Application for a non-material amendment following a grant of planning permission, Town and Country Planning Act 1990

Non material amendment to previous permission 2020/90762 for erection of two storey extension at Clifford House Farm, Cliff Hollins Lane, East Bierley, BD12 7ET
Application Number: 2022/92394

Scale	Alt	Scale	Alt	Date	Drawn	Checked	Drawing Number	Revision
1:100				12.01.20	MJD	mjd	19.030(2)-3001	A

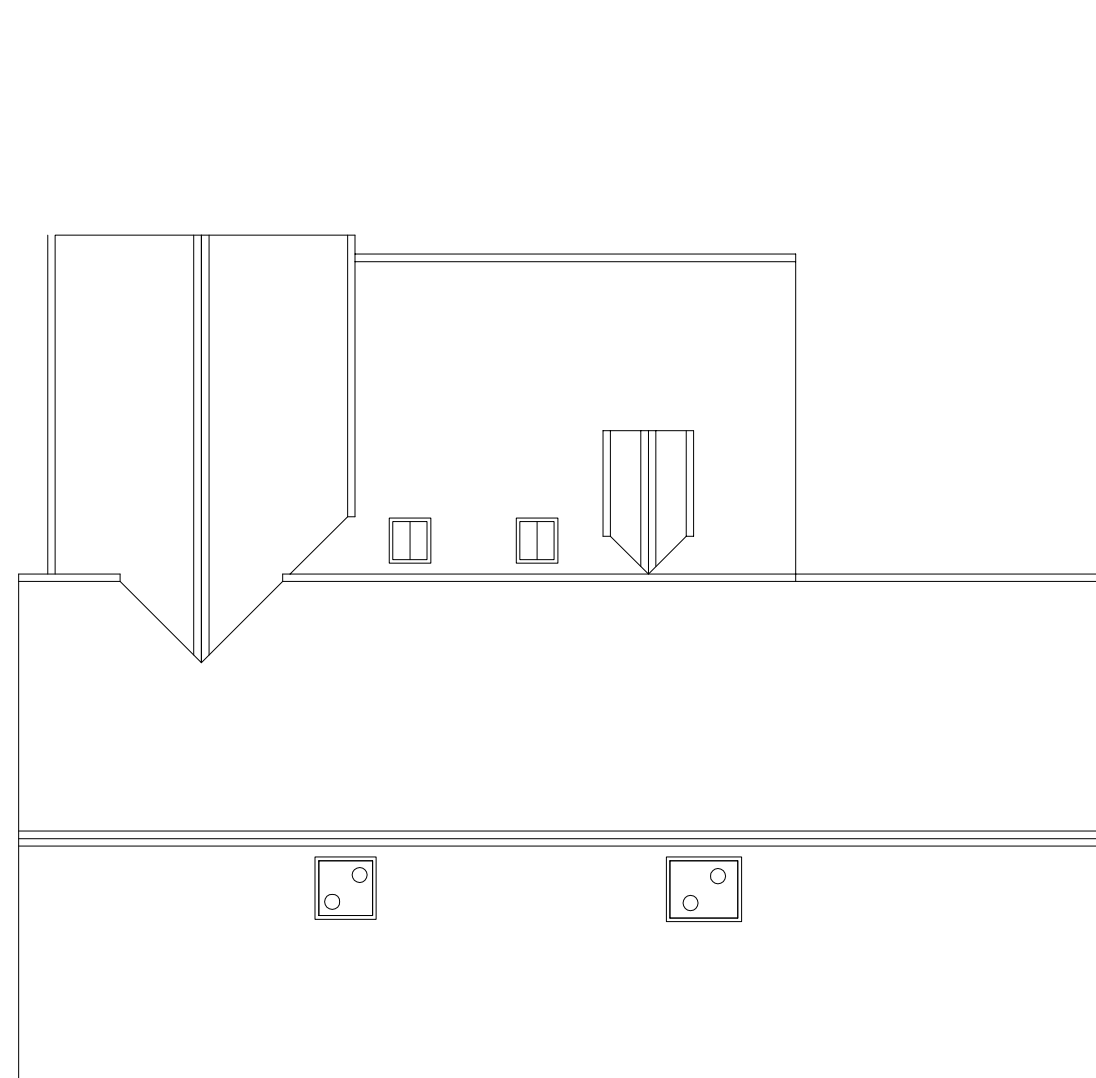
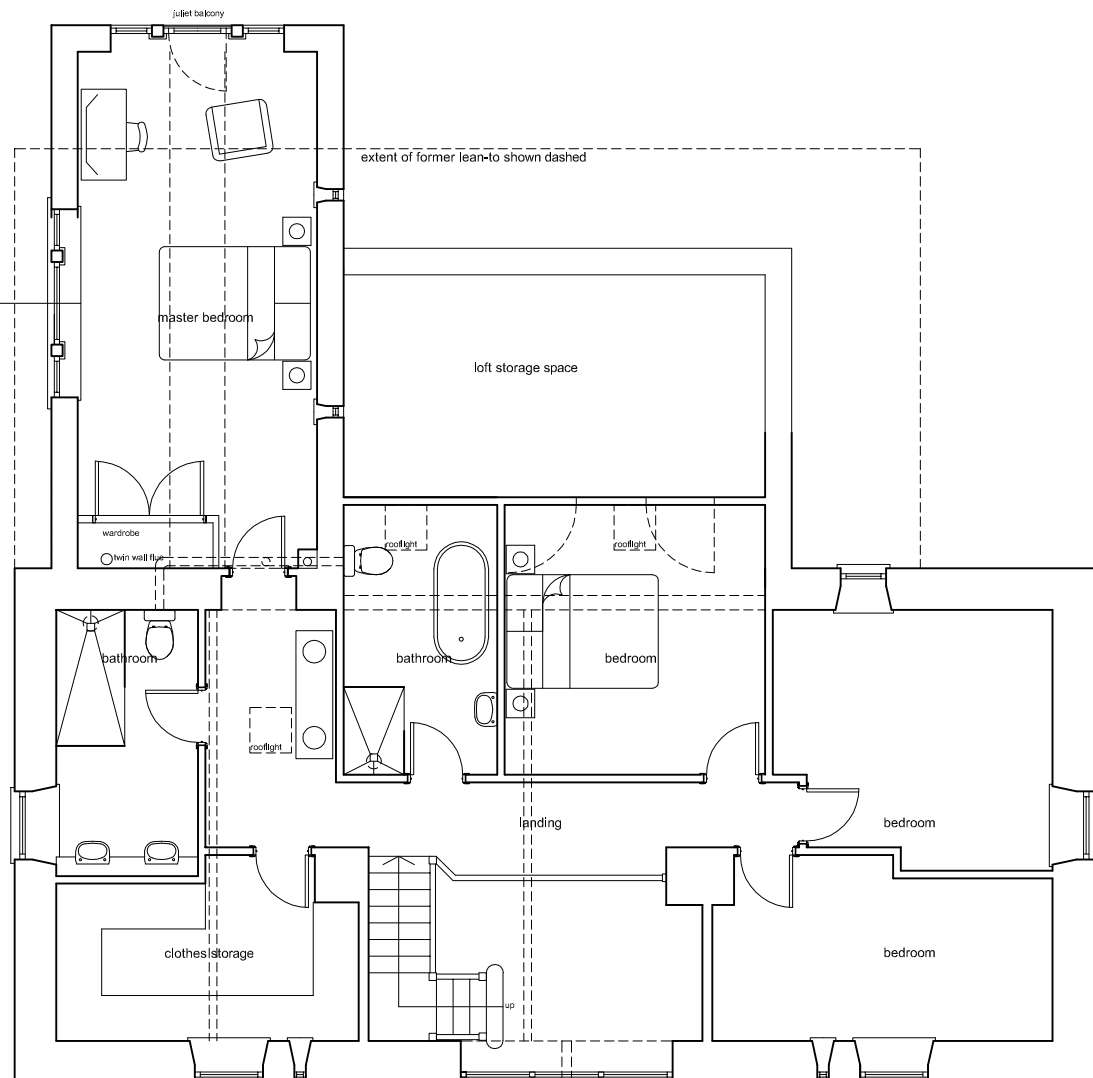
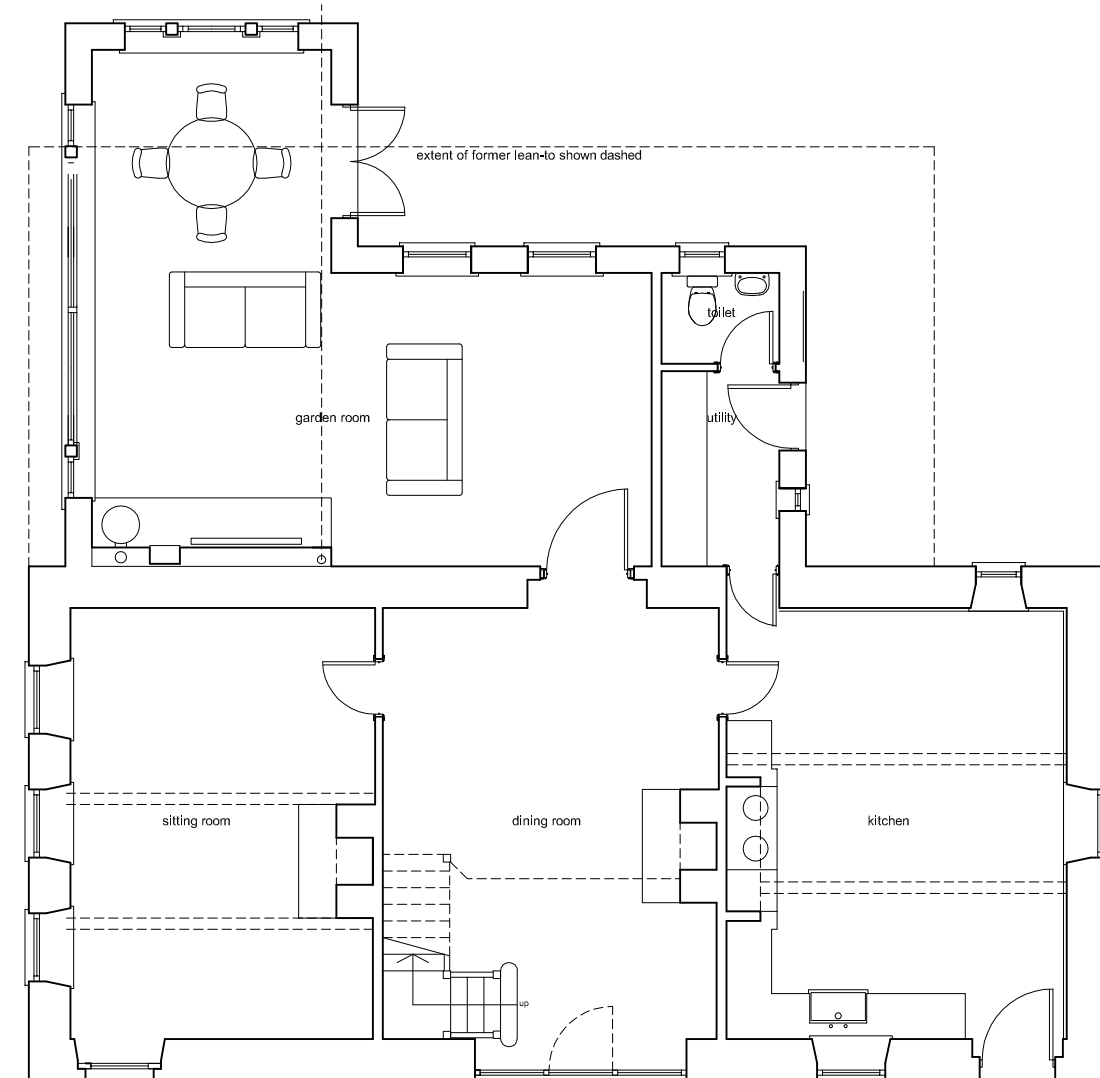
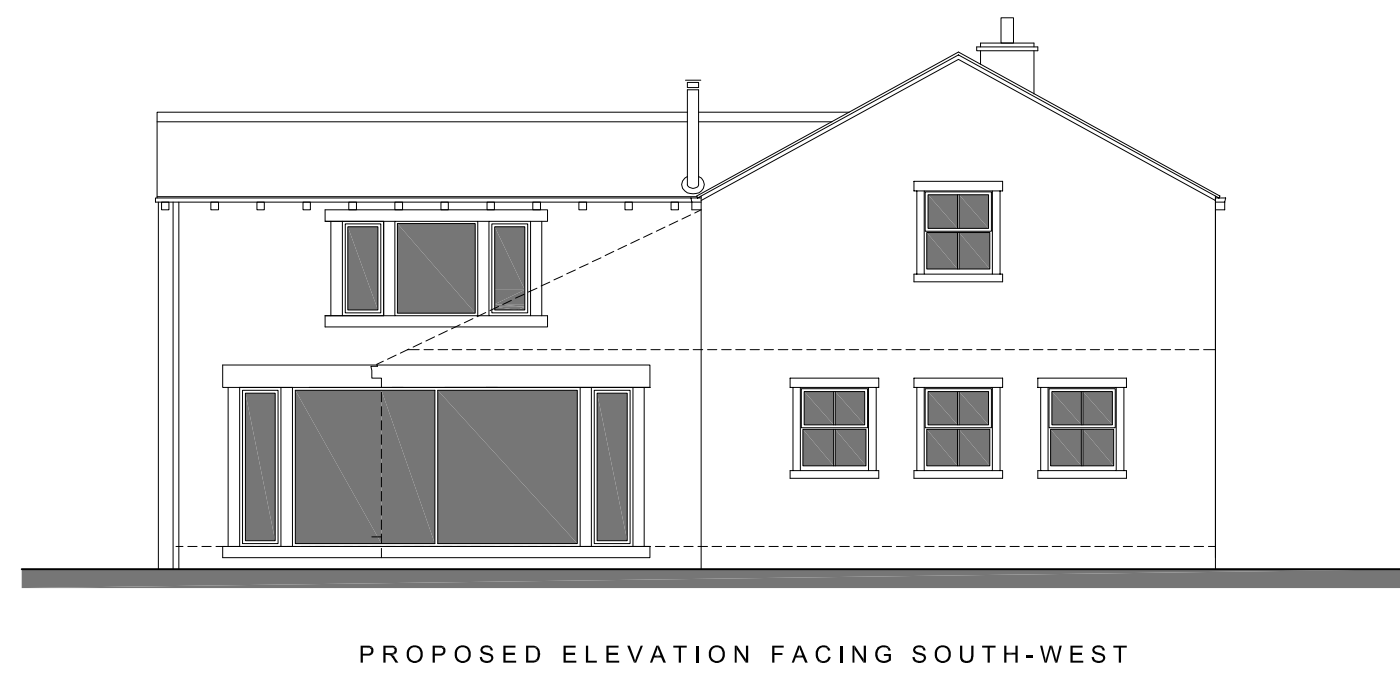
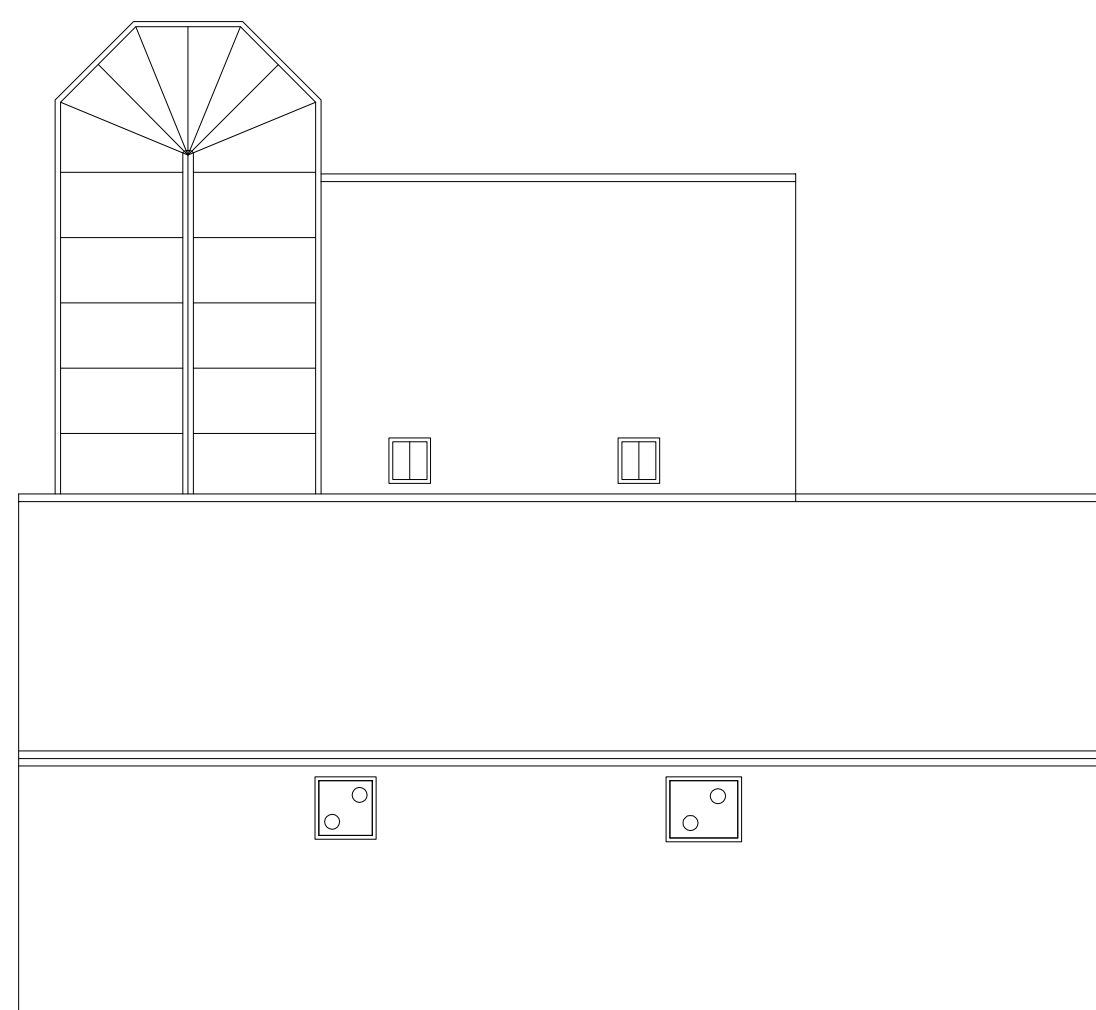
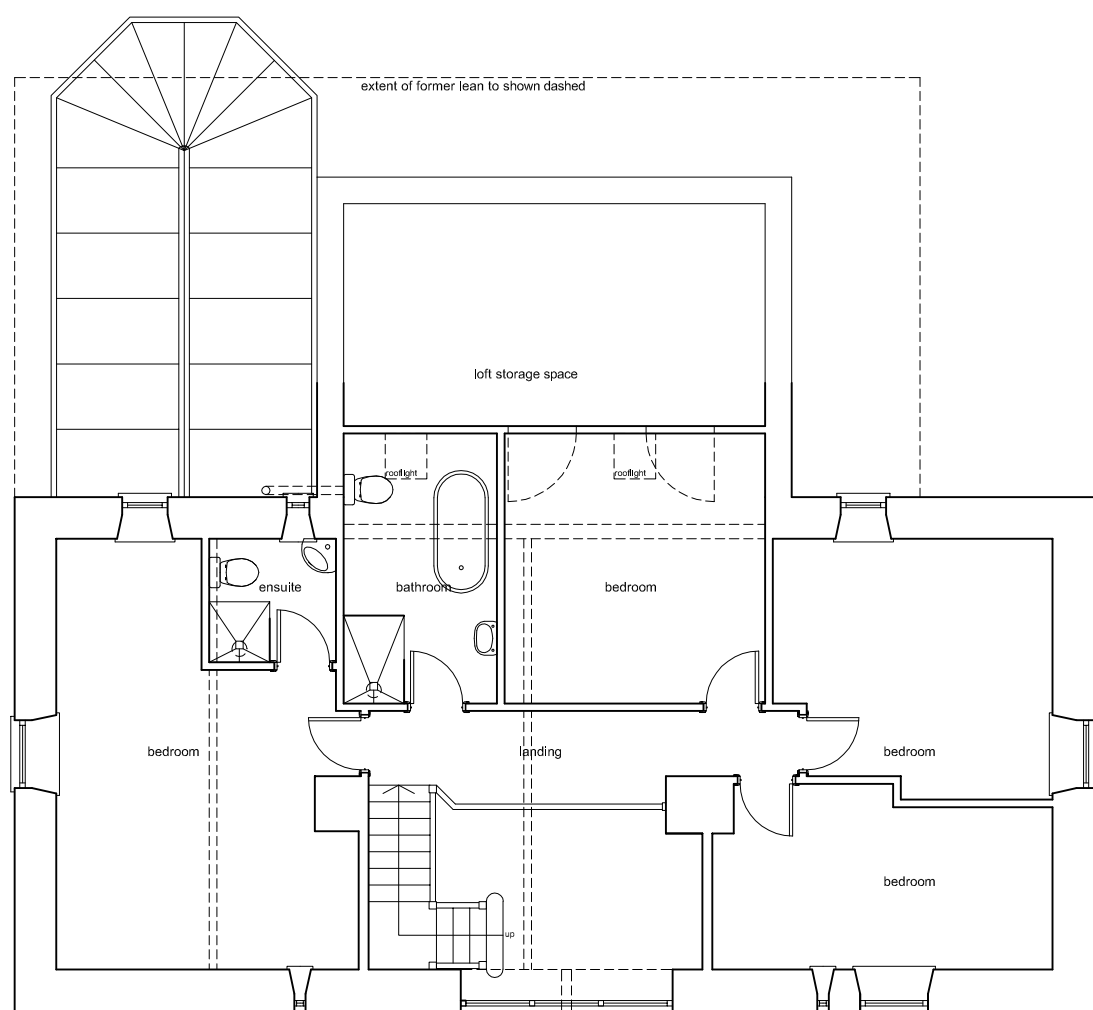
Thank you for your application dated 15-Jul-2022 for a non-material amendment to the above scheme. The amendment sought is to increase in size of proposed ground floor window facing south-west, removal of proposed first floor window facing north east and addition of first floor window facing south east. The amendments are shown on plan 19.030(2-)001a submitted 15/07/2022.

I confirm that the alterations are acceptable and may be considered as a non-material amendment to the approved drawings. It should be noted that this letter relates only to the non-material amendment sought and it is not a re-issue of the original planning permission. The two documents should be read together and as such, all conditions imposed on the original granting of planning permission apply to the proposal as now amended. A copy of this letter and the amended plans will be retained on the public record of approved documents.
